From: Mark Berry <Mark.Berry@kirklees.gov.uk>
Sent: 03 October 2024 11:14
To: Nina Sayers <Nina.Sayers@kirklees.gov.uk>
Cc: Highways DevelopmentControl <Highways.DevelopmentControl@kirklees.gov.uk>; Chris Dows <Chris.Dows@kirklees.gov.uk>
Subject: RE: 2022/92081 - Land at, Huddersfield Road/Leeds Road, Birstall, Batley, WF17 9AA

This application seeks approval to the demolition of an existing buildings and the erection of a retail food store with associated parking and landscaping at land at, Huddersfield Road/Leeds Road, Birstall, Batley.

Highways Development Management (HDM) comments:

Title: Proposed Site Plan
Client: Wharfedale Ltd.

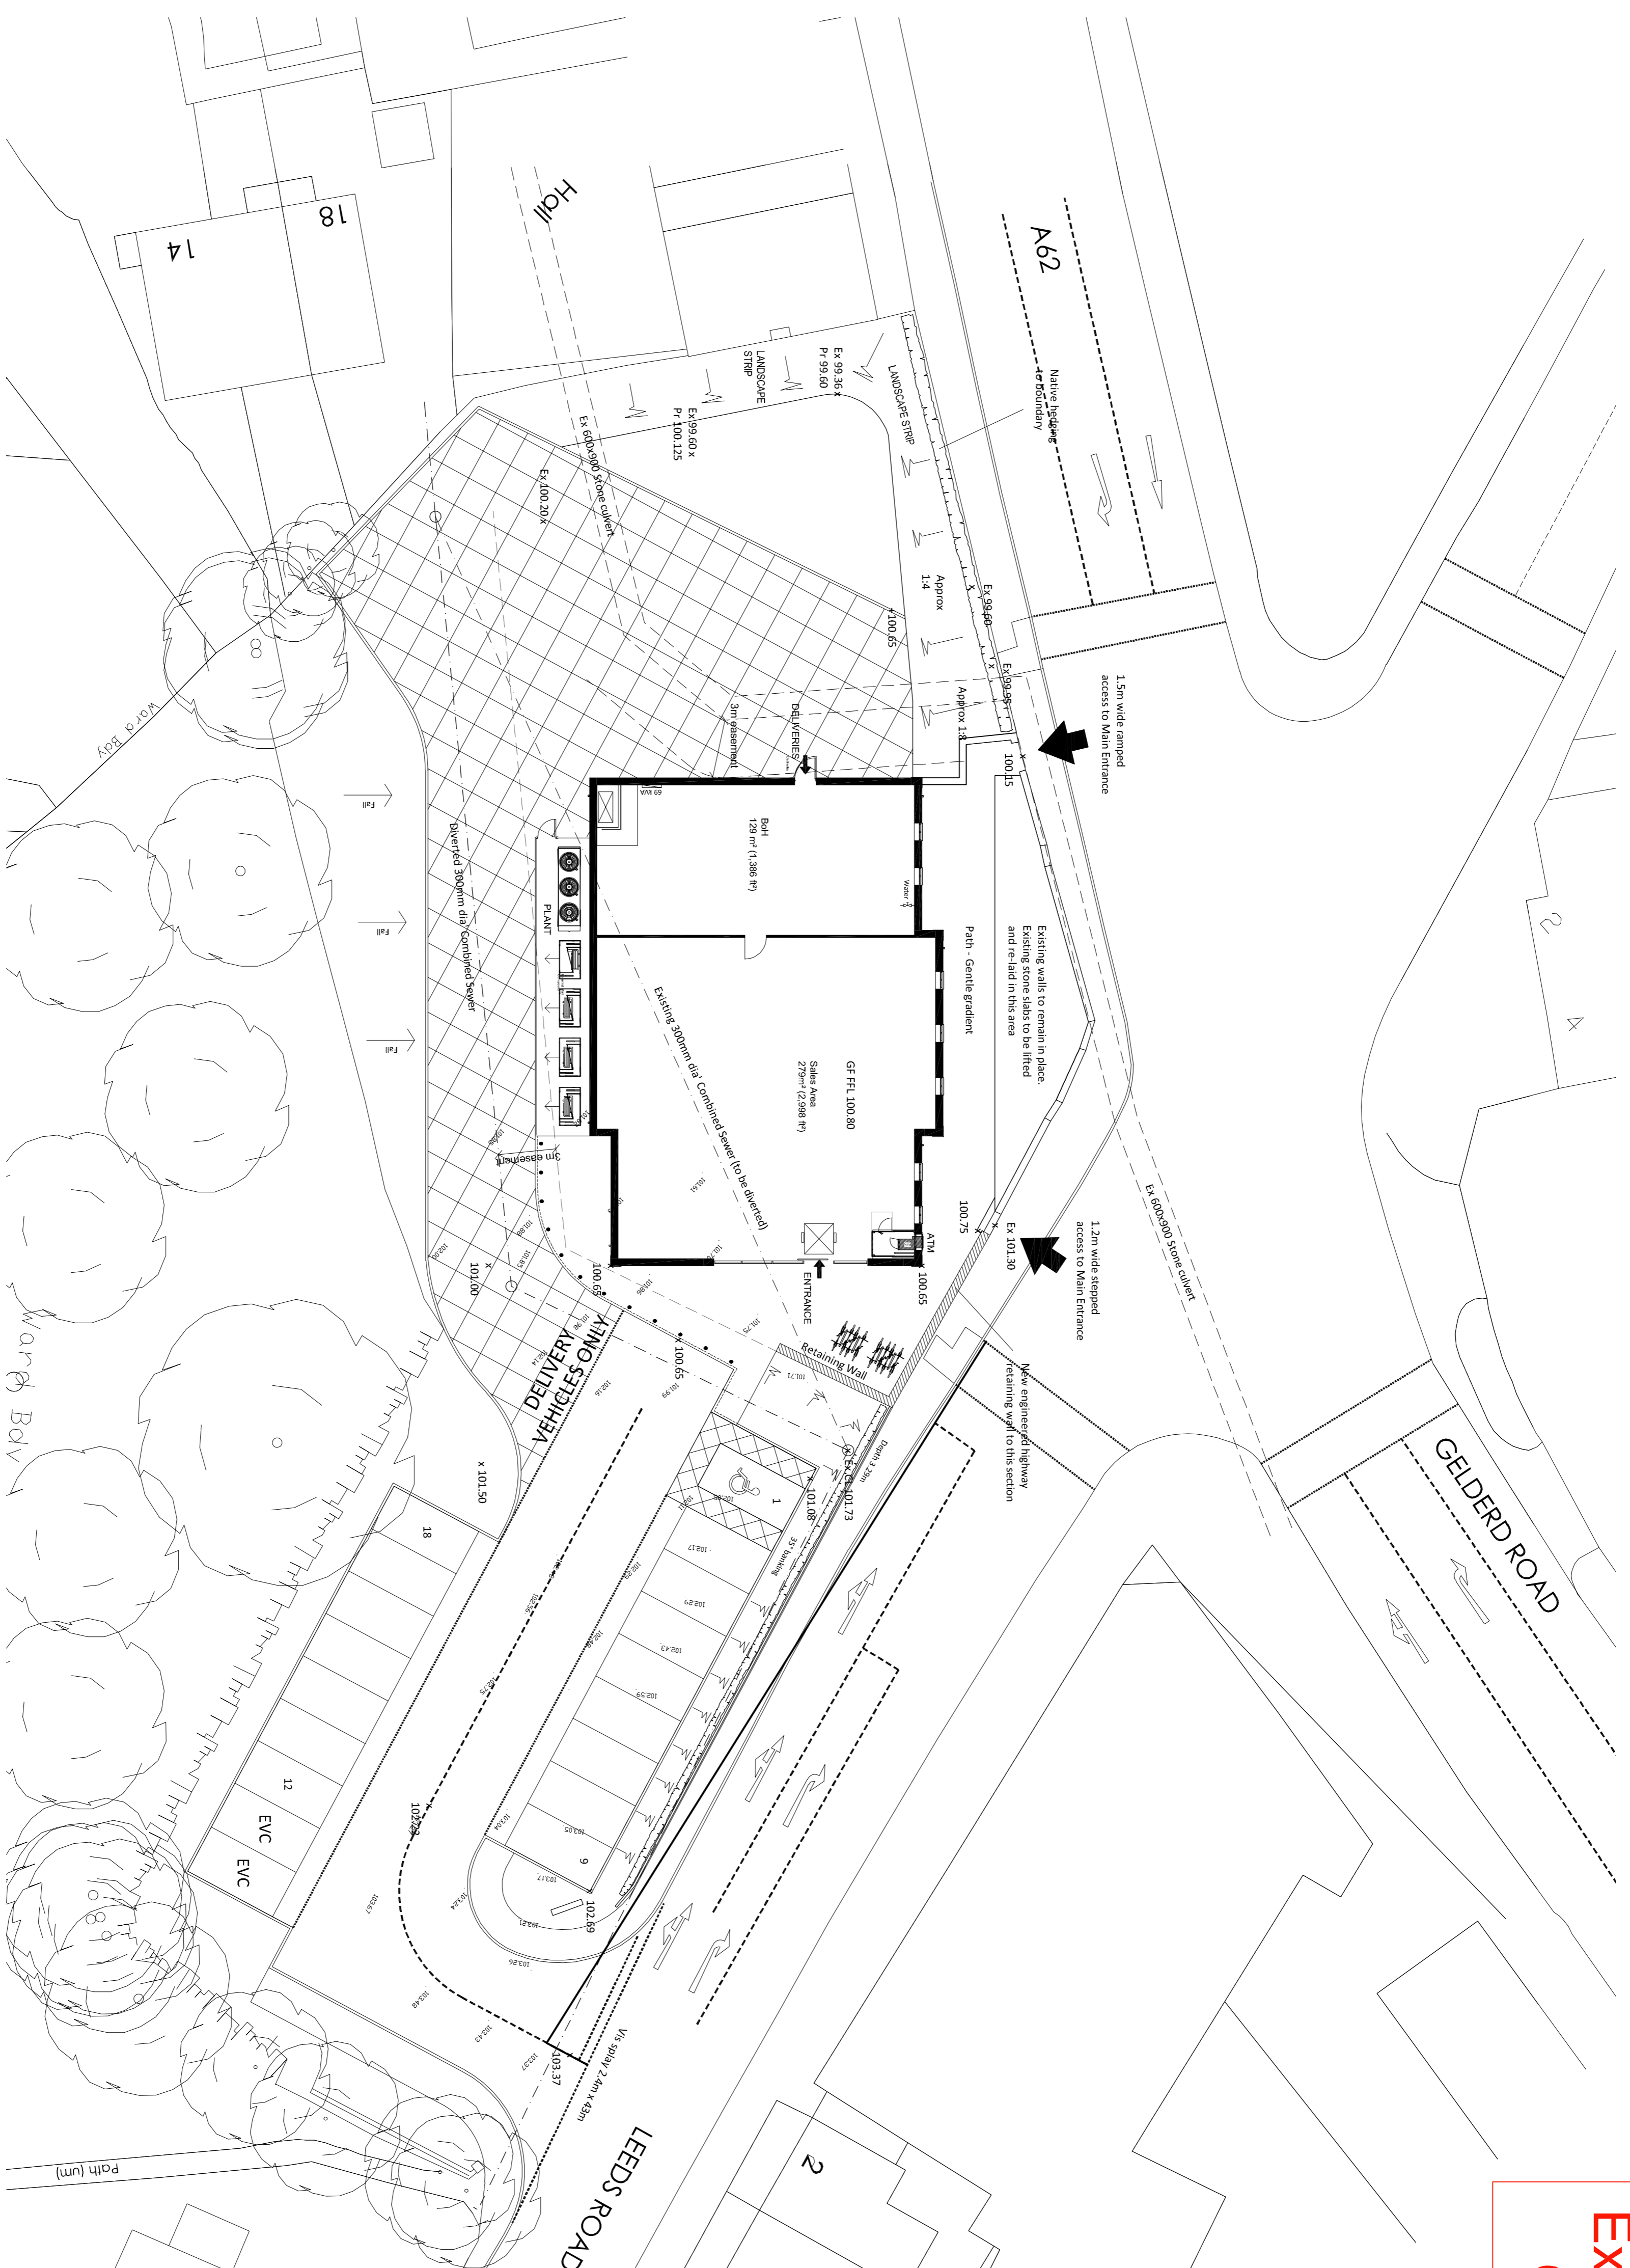
Whilst the vehicle swept path provided by Paragon Highways demonstrate that a 16.5 m articulated lorry can theoretically access and turn within the site, the swept paths are tight to kerb line, vehicle parking spaces and other features within the site and a Service Management Plan should therefore be conditioned which should restrict the size of vehicles that can enter the site.

Whilst this is not considered ideal by HDM given that there are just 6 buses per hour and the footway is to be widened which should provide space of people waiting for the bus to stand, these proposals are considered an improvement when compared to the existing situation and on-balance the proposal for the bus stop to remain is therefore considered acceptable.

Service Vehicle Management Plan.

Turning facilities to be provided.

Measures to Managing Parking to Leeds Road site frontage (7am to 6.30pm Mon to Sat to no parking at any time).

Keep clear marking or box junction marking to be provided.
